MERIDIAN RANCH: ESTATES AT ROLLING HILLS RANCH NO. 2

PUD DEVELOPMENT, PRELIMINARY PLAN AND FINAL PLAT

LETTER OF INTENT

JULY 2020

REX ROAD  
MINOR ARTERIAL

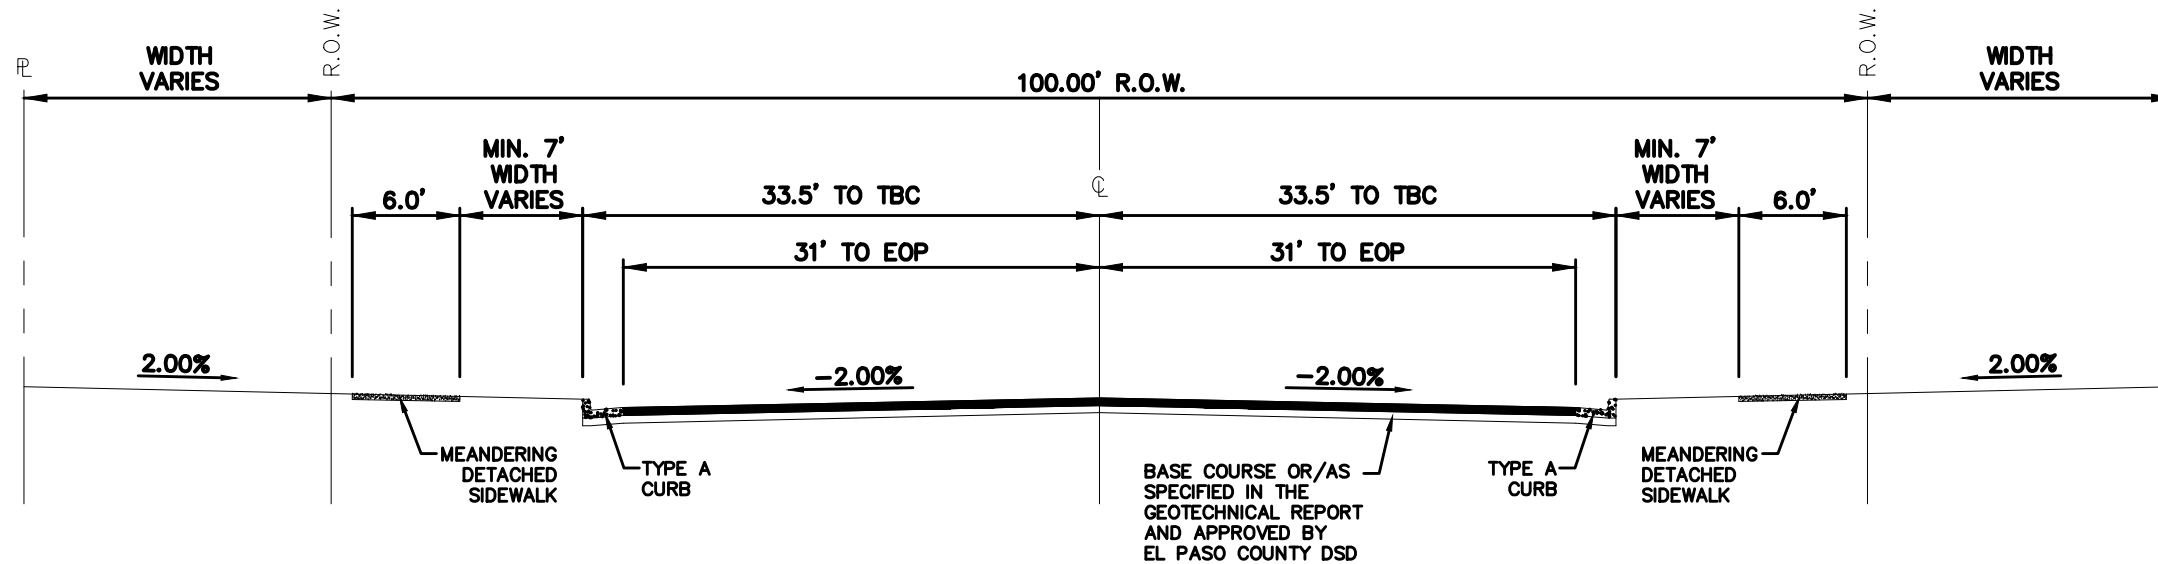
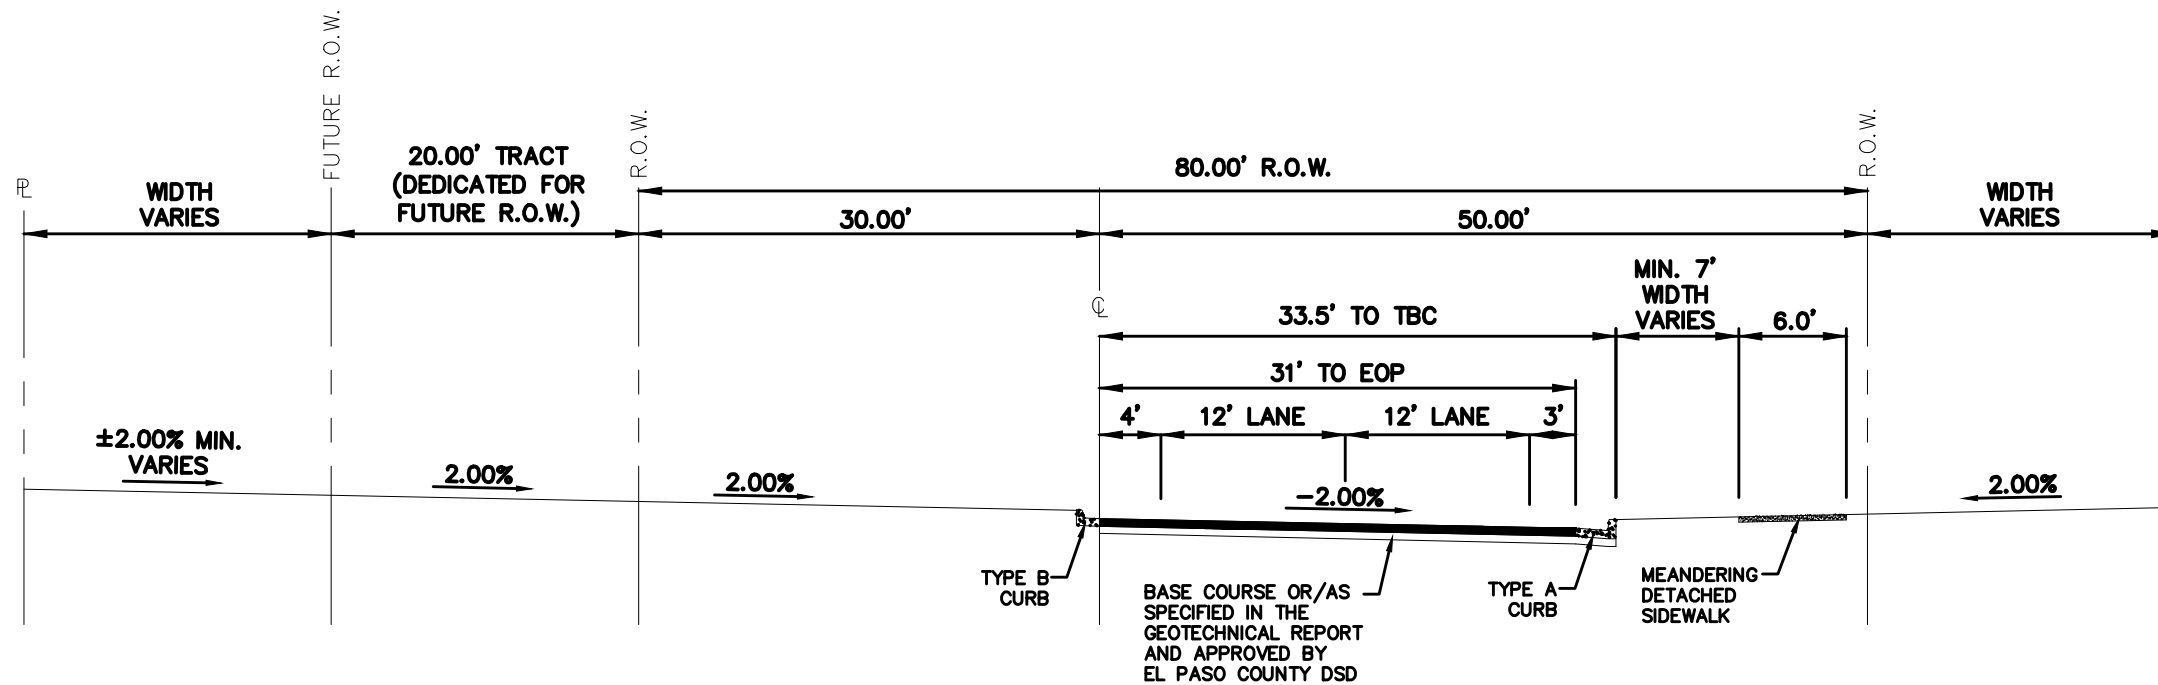
The section of Rex road below (west of Sunrise Ridge) was already approved with Estates at Rolling Hills Ranch Filing 1. This deviation is requesting for the section of Rex Road east of Sunrise Ridge. The table above indicates that the roadway is proposed to be a Residential Urban Collector yet the text below indicates a half section of roadway. Also PUDSP199 that recently went to the BoCC indicated this section of roadway as a half section of the Urban Minor Arterial. Please revise accordingly.

NES RESPONSE:
Revised as noted.
